Department of Fish and Wildlife

April 20, 2010

Subject: Yellowstone Trail Estates (LP-09-00006) Plat revision and amended Critical Areas Report – Comments related to revisions.

- 56,744sf Buffer Impact
- 58,166sf Buffer Addition
- 1,935sf Wetland Impact
- 1,967sf Wetland Creation

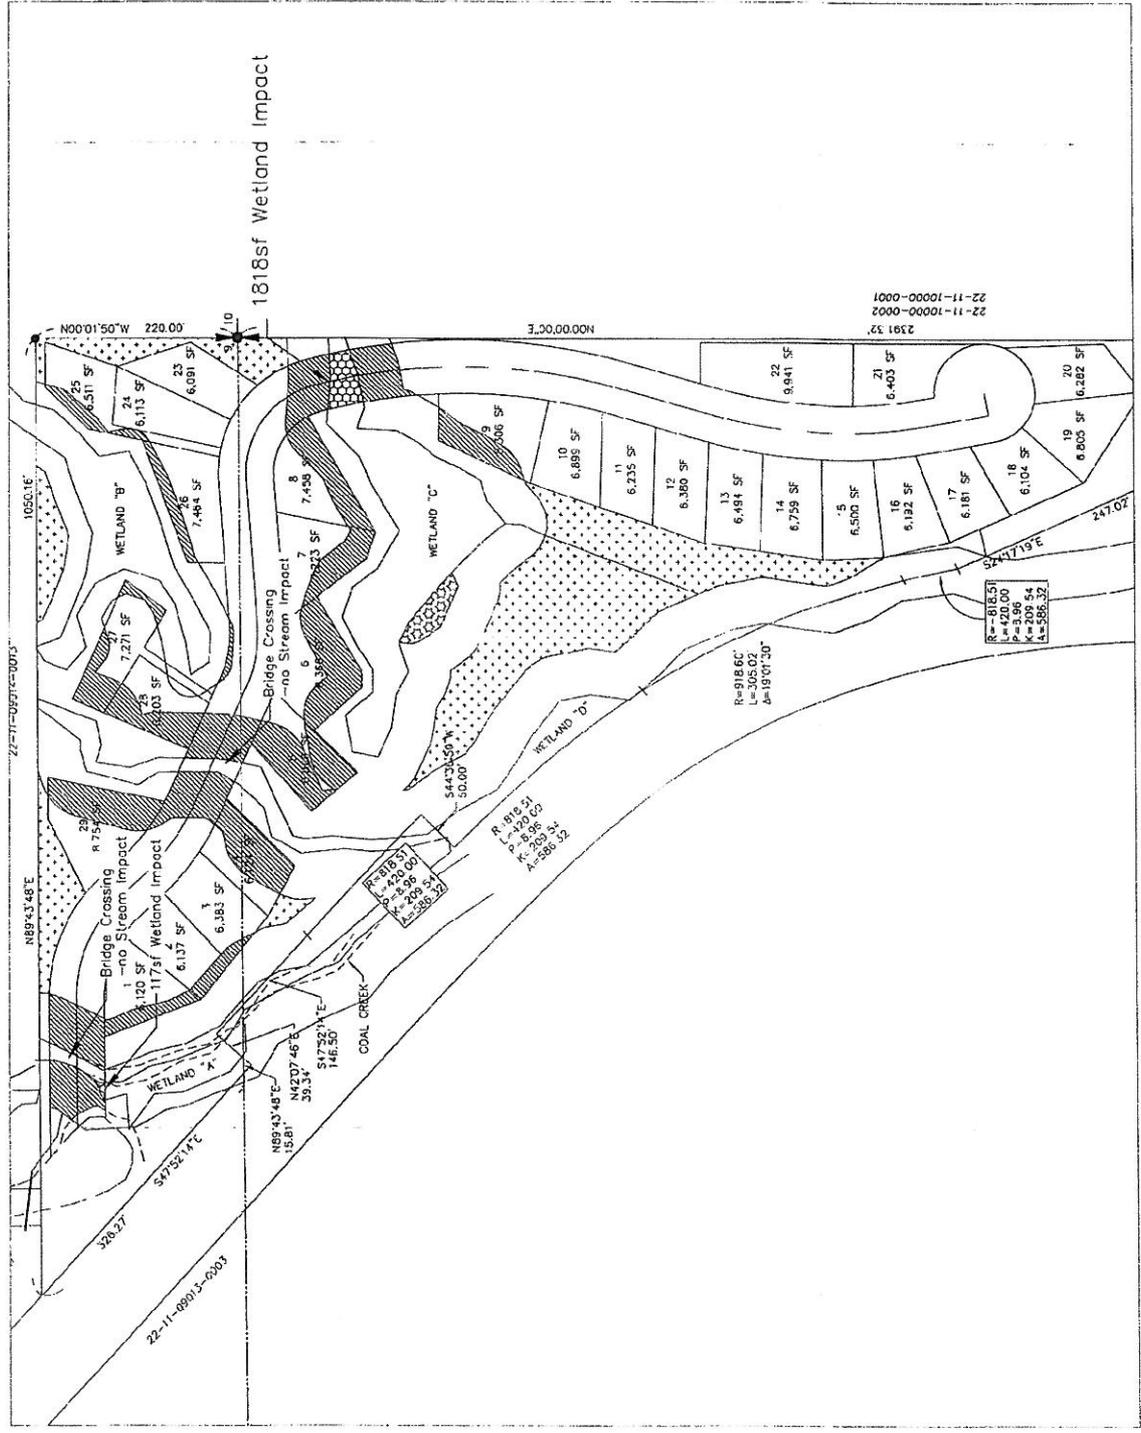
- b. **Plant list for the created wetland.** The plant list on plan sheet W-1 of the Conceptual Mitigation Plan does not include any herbaceous plants for the created wetland. Presumably this is because salvaged wetland soils will be placed on the new constructed wetland site and this salvaged soil should have a seed bank that includes herbaceous native wetland plants. However, some temporary cover of the site will be needed for short term soil protection and erosion control. The excavation to create the wetland will likely be done during the late summer dry season, so there will be little time between the wetland construction and the onset of fall rains. A seed mix of suitable temporary erosion control grasses and/or sedges should be considered to help stabilize the site for the first couple years. (Additional erosion control BMPs may be needed prior to fall rains.)

- c. **Use of local transplants.** The Conceptual Mitigation Plan suggests that local transplants of native sedges could be used to maintain species composition. We concur. This is a prudent measure and should be part of the final plan. This work should be directed by someone with expertise in wetland plant identification and wetland restoration.
